A303 Sparkford to Ilchester Dualling Scheme TR010036

8.10 Draft Statement of Common Ground with Queen Camel, West Camel and Sparkford Parish Councils

STATEMENT OF COMMON GROUND

Version	Date	Status of Version
Rev 1	January 2019	Draft for Examination Issue

Drawing Title  
**FIGURE 2.9  
LOCATIONS OF TEMPORARY WORKS AREAS REQUIRED  
DURING CONSTRUCTION - SHEET 2 OF 4**

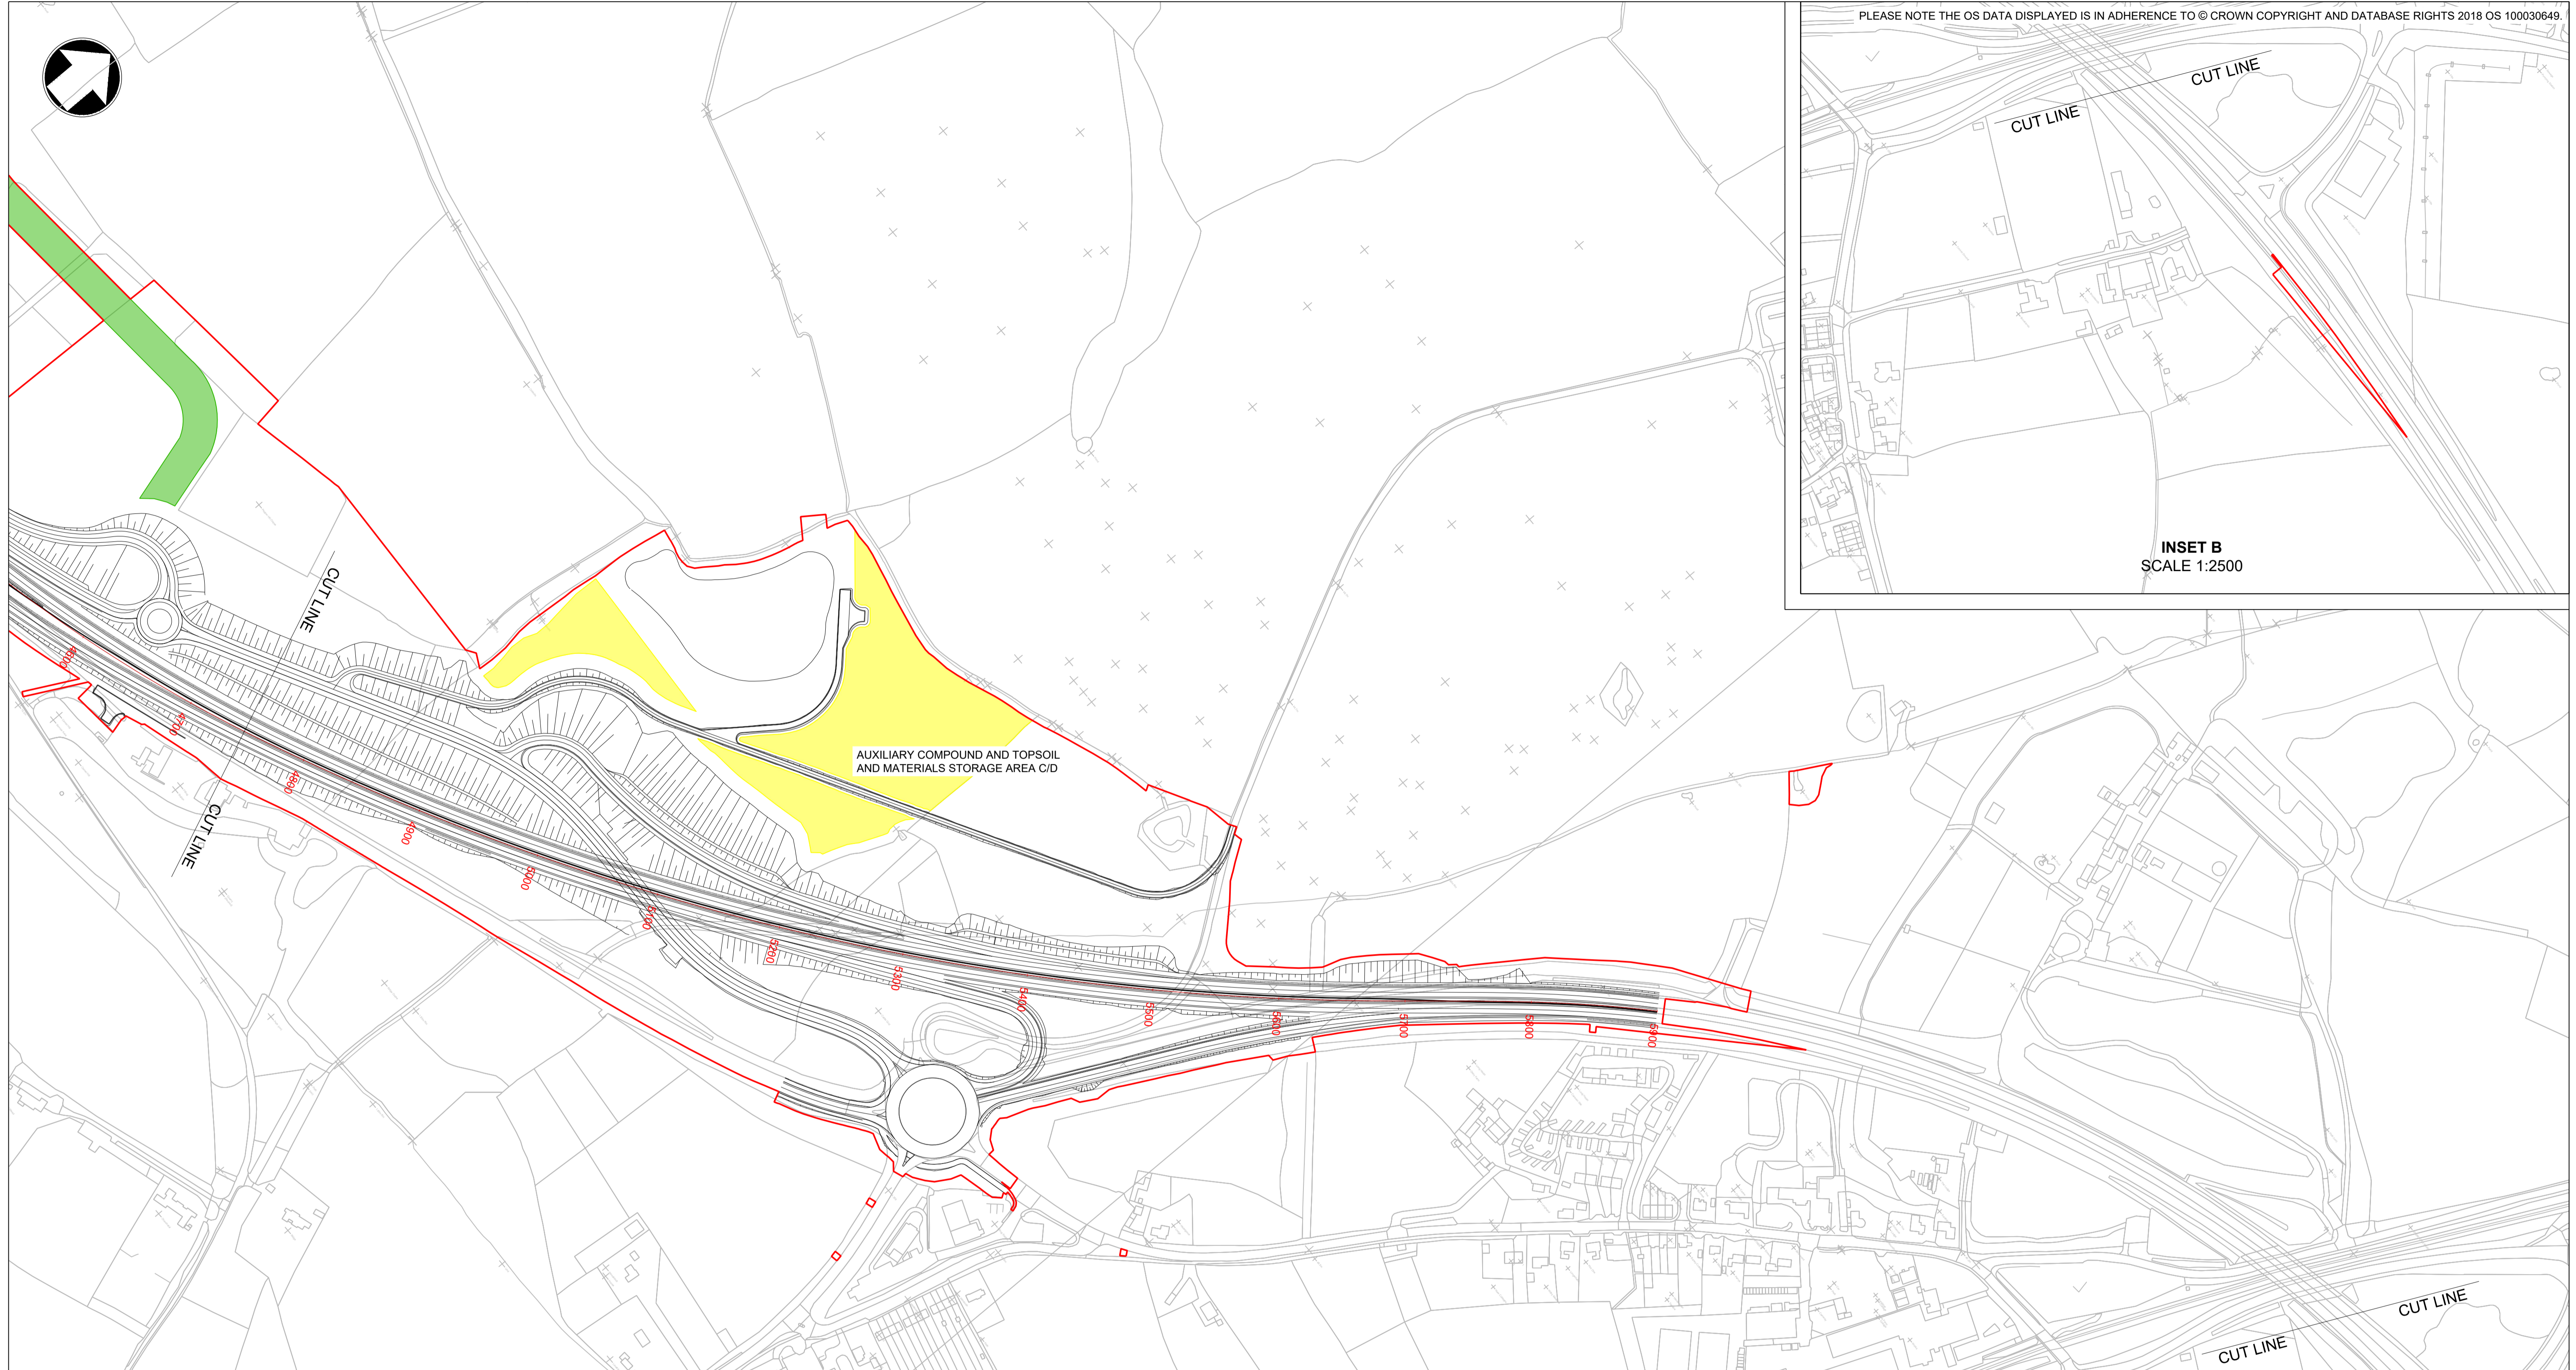
Topic	Sub-section	Comment	Highways England response	Status
	Traffic management during construction	<p>Proposed diversion via A359 - The applicant's proposed diversion of A303 traffic through Queen Camel, Marston Magna and Mudford villages into Yeovil to return via the A37 to the A303 at Ilchester are totally and utterly unacceptable to these local communities. The applicant's bland assurances that traffic will be 'managed' through a TMP do not reassure communities that suffer congestion 'rat-running' through unclassified local road each and every summer and whenever the A303 becomes congested, in either direction. Drivers will follow their SatNav devices along unclassified roads in an attempt to find a shorter diversionary route which will endanger the lives of people living in local communities.</p> <p>The Joint Councils respectfully suggest that the DCO application include details of how the applicant will mitigate the adverse impact of self-diverting traffic and further investigation be undertaken in to the provision of AMPR cameras on junctions accessing routes where HGV traffic is banned.</p> <p>We also ask that the applicant be required to mitigate traffic along A359 through High St Sparkford, Queen Camel and on the unclassified roads through West Camel.</p>	<p>The Traffic Management Plan (TMP) is being developed in consultation with Somerset County Council, and will eventually contain measures for the prevention and mitigation of the adverse impacts of self-diverting traffic. A draft of this document is provided as Appendix B5 to the Outline Environmental Management Plan (APP-148).</p> <p>It should be noted that the Development Consent Order (DCO) application also involves the temporary closure of the A303 for brief periods of time and diversion of traffic along the A359 using the diversion route that is currently agreed between Highways England and Somerset County Council. The final TMP will contain details of how the impacts of this closure will be managed.</p>	UNDER DISCUSSION

Topic	Sub-section	West Camel Parish Council comment	Highways England response	Status
	During Construction	villages. It will be vital to ensure traffic from the A303 is not diverted through the villages during the construction period.	<p>Somerset County Council, and will eventually contain measures for the prevention and mitigation of the adverse impacts of self-diverting traffic. A draft of this document is provided as Appendix B5 to the Outline Environmental Management Plan (APP-148).</p> <p>It should be noted that the Development Consent Order (DCO) application also involves the temporary closure of the A303 for brief periods of time and diversion of traffic along the A359 using the diversion route that is currently agreed between Highways England and Somerset County Council. The final TMP will contain details of how the impacts of this closure will be managed.</p>	<i>DISCUSSION</i>

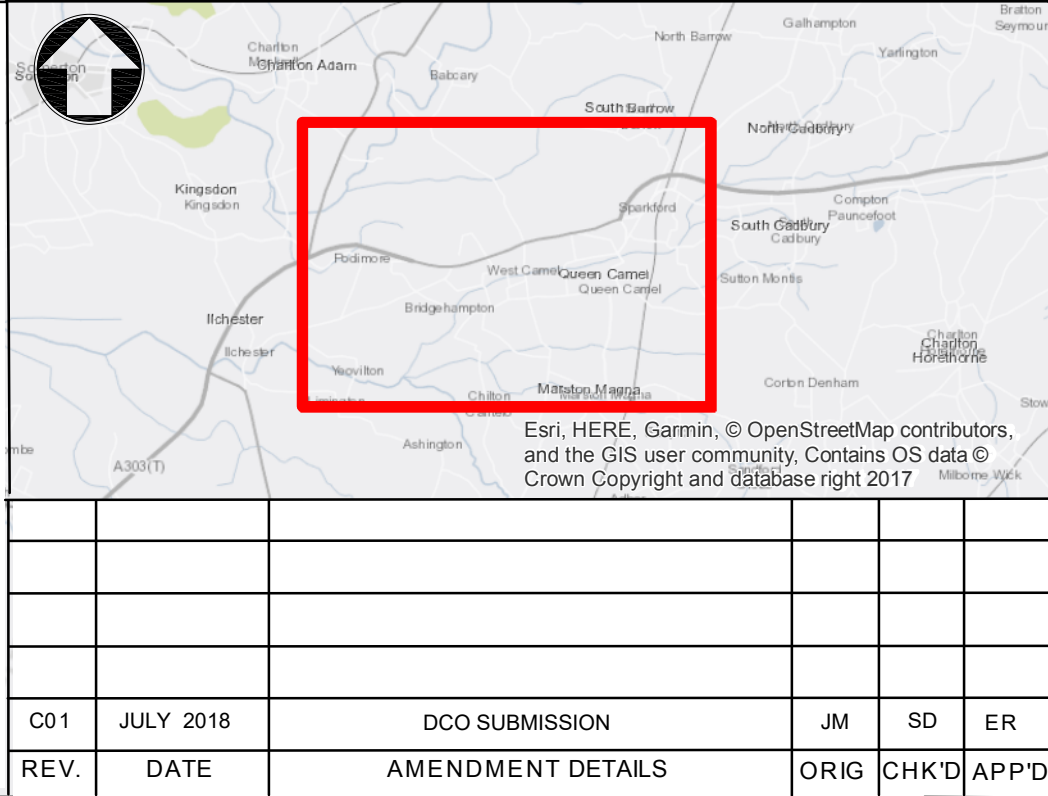
Topic	Sub-section	Sparkford Parish Council comment	Highways England response	Status
	Noise Mitigation	It is important as the road is to be constructed on an embankment across Hazelgrove Park that low noise surfacing is used and sound barriers are deployed to reduce the noise affecting Hazelgrove School to the North, Wolfester Terrace and Sparkford Services to the South. Noise levels must meet current legislation and should be re-assessed to ensure they do.	Low noise surfacing has been proposed and a noise model has been used to inform the noise mitigation strategy.	AGREED
	Sparkford Services	As a Parish Council we are concerned about the long term future of Sparkford Services, given the poor design of the Hazelgrove Junction. The Petrol Station and McDonalds employ in excess of 100 people between them. The junction design will not ensure Sparkford Services remain viable as the long protracted eastbound slip road will deter motorist from using Sparkford Services - they will travel on to use the services elsewhere.	The junction has been designed to ensure that these businesses remain accessible and a signing strategy will be developed to ensure passing motorists are aware that these facilities exist.	UNDER DISCUSSION
